Submission to Planning Inspectorate, National Infrastructure Planning:

Ref. TR010025

Prepared by Dr. G.M. Reeves for the **Stonehenge Alliance, Reference No. 2001870**

Initial Assessment of Principal Issues: Section 7: Flood Risk, groundwater protection and land contamination

PROPOSED BORED TUNNEL - (WORK No. 1F)

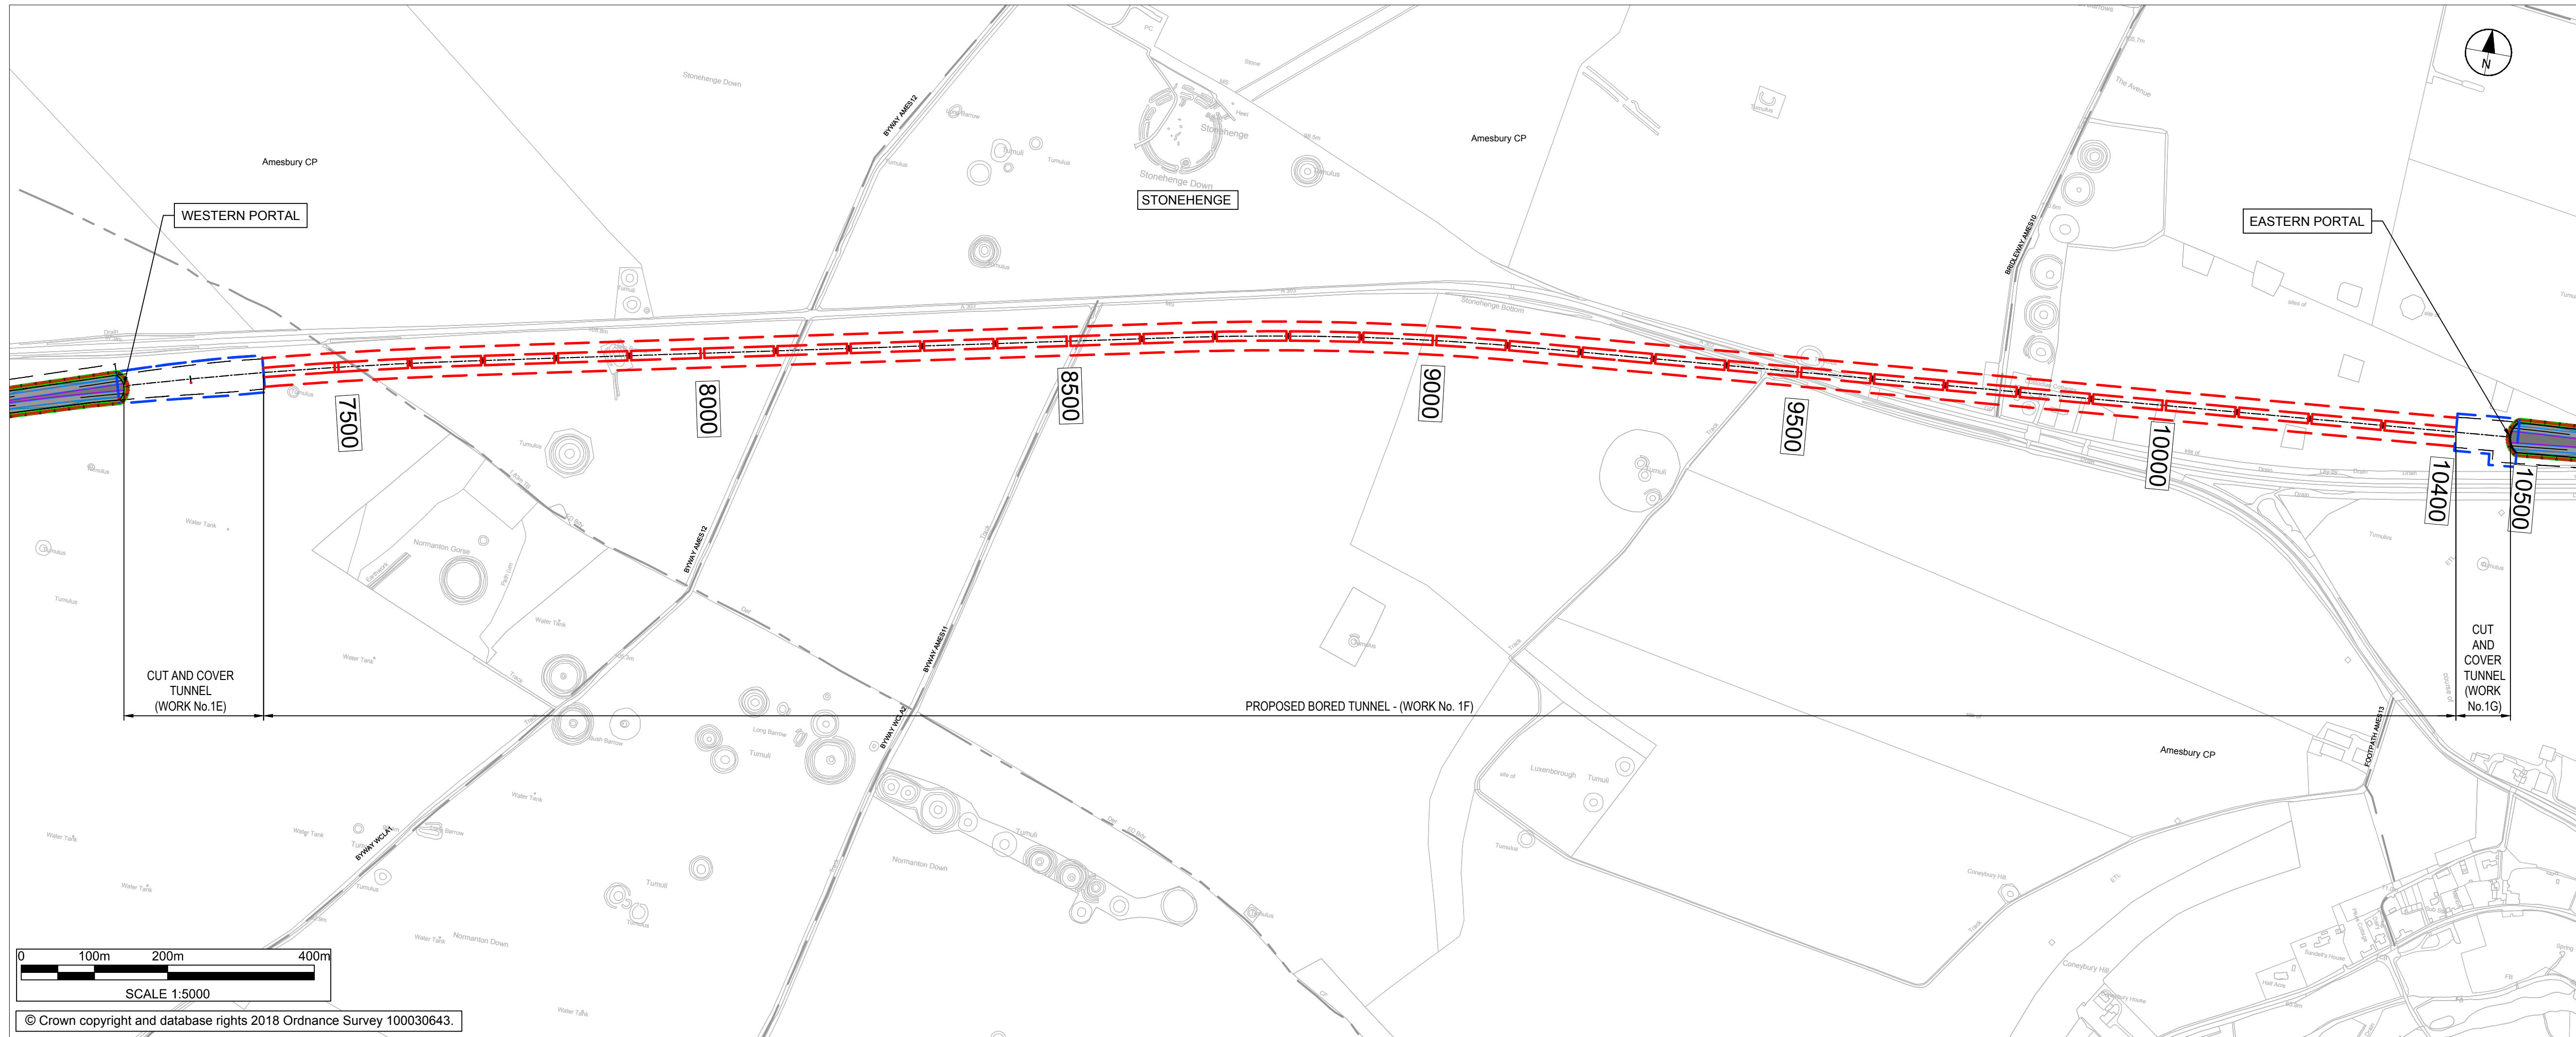
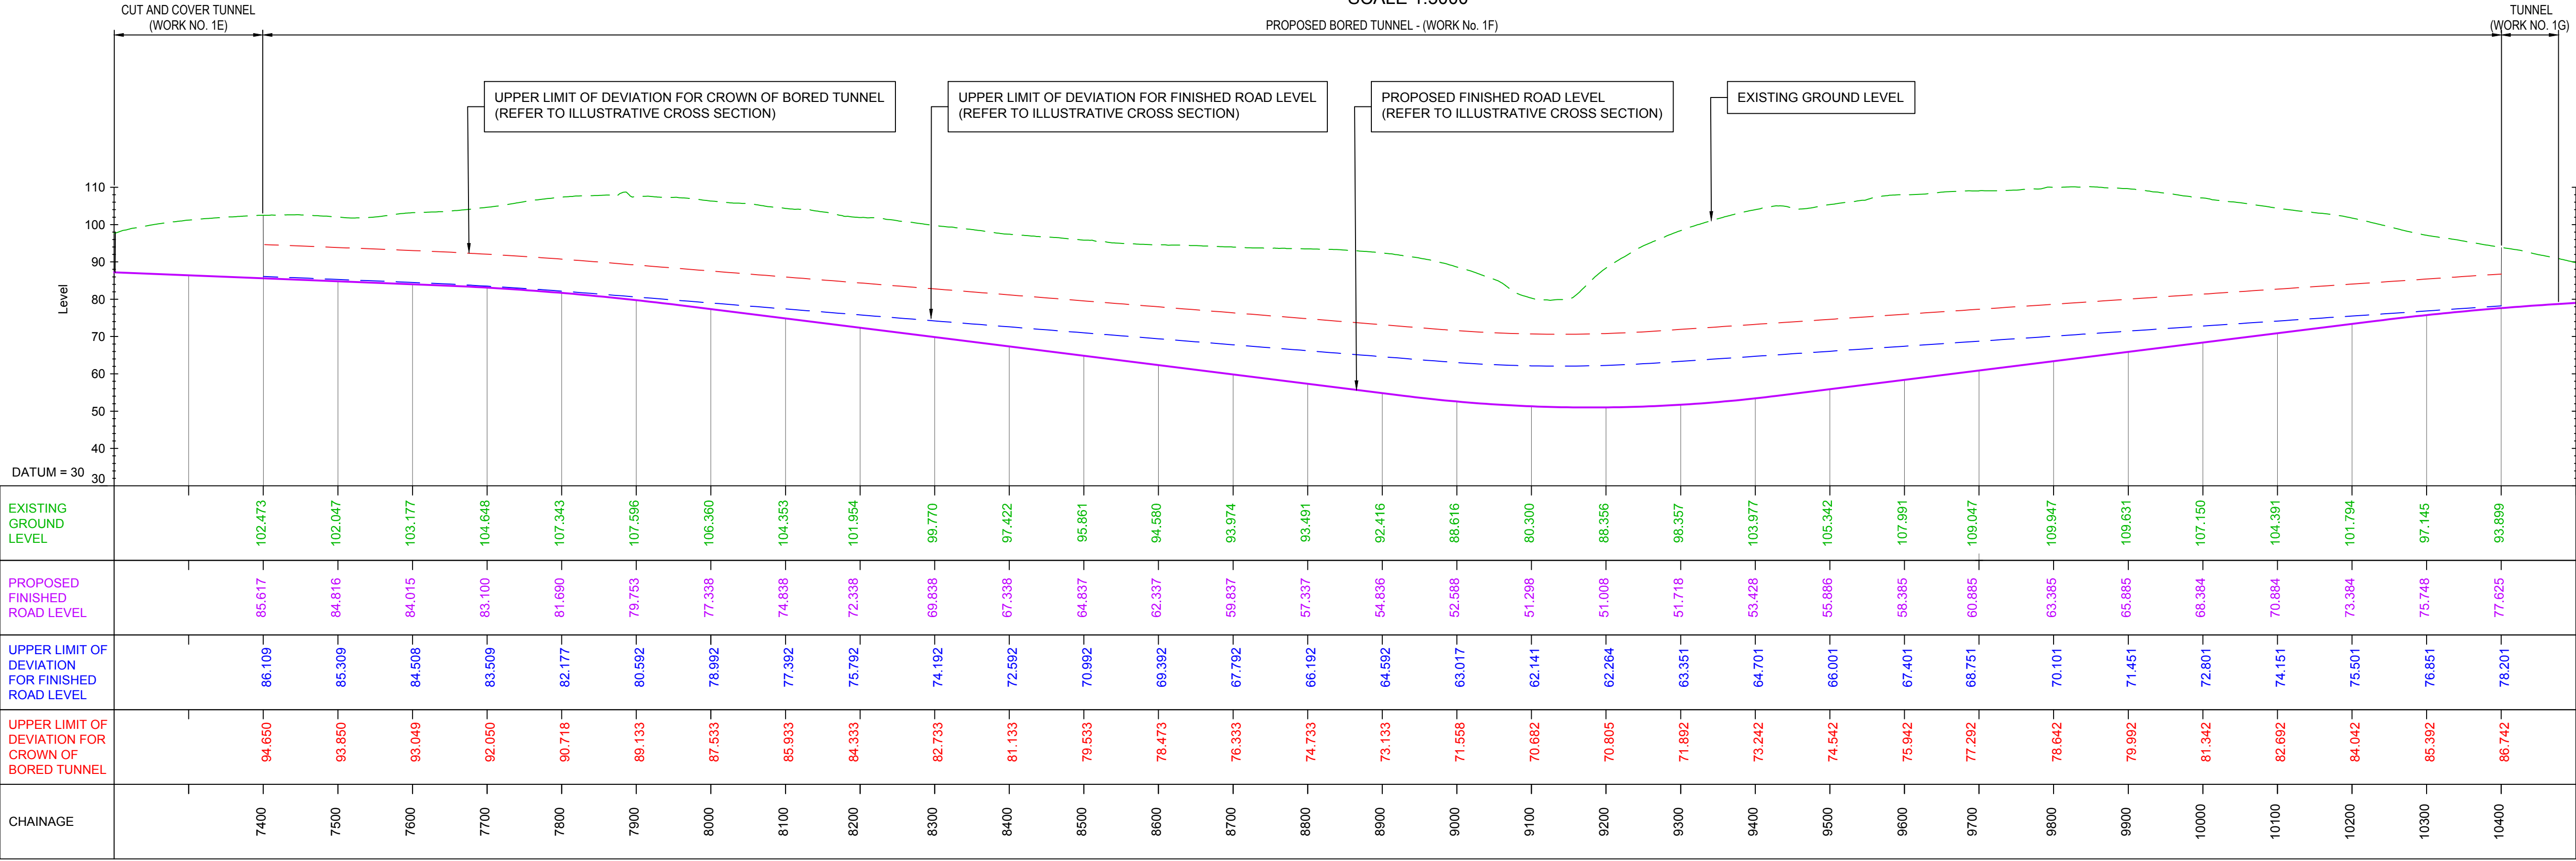
Unless ground stabilisation techniques, such as a bentonite shield-based Tunnel Boring Machine and/or grouting of fractured bedrock are used, there is a high risk of tunnel face collapse, void migration, and potential sinkhole creation upwards from the tunnel crown. To obviate these concerns, it is envisaged that there will be a significant uptake of bentonite slurry/grout into the highly fractured zones of the Chalk along the line of the tunnel. This will be necessary to maintain tunnel stability, especially on the tunnel shoulders and crown.

Closed face TBM systems (with bentonite slurry on a full-face tunnelling machine), combined with the possible necessity of grouting from surface with groundwater control by dewatering methods are most likely to be used. This will be required in the Stonehenge Bottom area, at cross-passage locations, (at high groundwater level periods during construction) and will create a permanent, extensive, diversionary feature to the current groundwater flow system.

2.3 As a consequence of the above information on the occurrence of poor quality rock along the line of the proposed tunnel, and the relatively shallow depth of the middle portion of the tunnel route in the Stonehenge Bottom area, it has been proposed by HE that a "slurry shield" method of closed-faced tunnelling would be the most likely tunnelling method to be adopted.

This depends on a full-face tunnel boring machine (TBM) with a bentonite-mud based slurry forming external additional long-term grout support to the strata surrounding the tunnel face and sides.

Therefore on completion of each tunnel drive (two circa 2.9km long drives of 13m diameter approx.), an annulus of unpredictable extent will surround the pathway excavated by the TBMs, outside the tunnel lining. If overbreak occurs at the tunnel crown or wall failure at the flanks, due to the highly fractured nature of the Chalk, surface based grouting from a network alignment of new additional grout injection boreholes may be necessary.

2.6 During a TBM drive, especially in poor quality (i.e. weak) rock, there is the possibility for vibration caused by the tunnelling process. This may cause induced fracture migration and settlement in overlying strata transmitted upwards from the tunnel crown and shoulders through overlying, progressively weak strata, towards the surface. In the extreme, subsidence could migrate to surface levels.

Settlement of badly fractured rock zones and possible migration through existing voids and fracture zones may cause overbreak at the tunnel crown which could migrate to surface, forming “sinkholes”. Compaction and consolidation of structureless and weak chalk rock could occur, with possible compaction of deeper soils up towards the ground surface.

4.1 The creation of what would effectively be a “groundwater cut-off dam”, at depths of up to 40 metres below ground level, with grout invasion potentially penetrating some distance from the tunnel bores, will considerably affect long-term groundwater conditions.
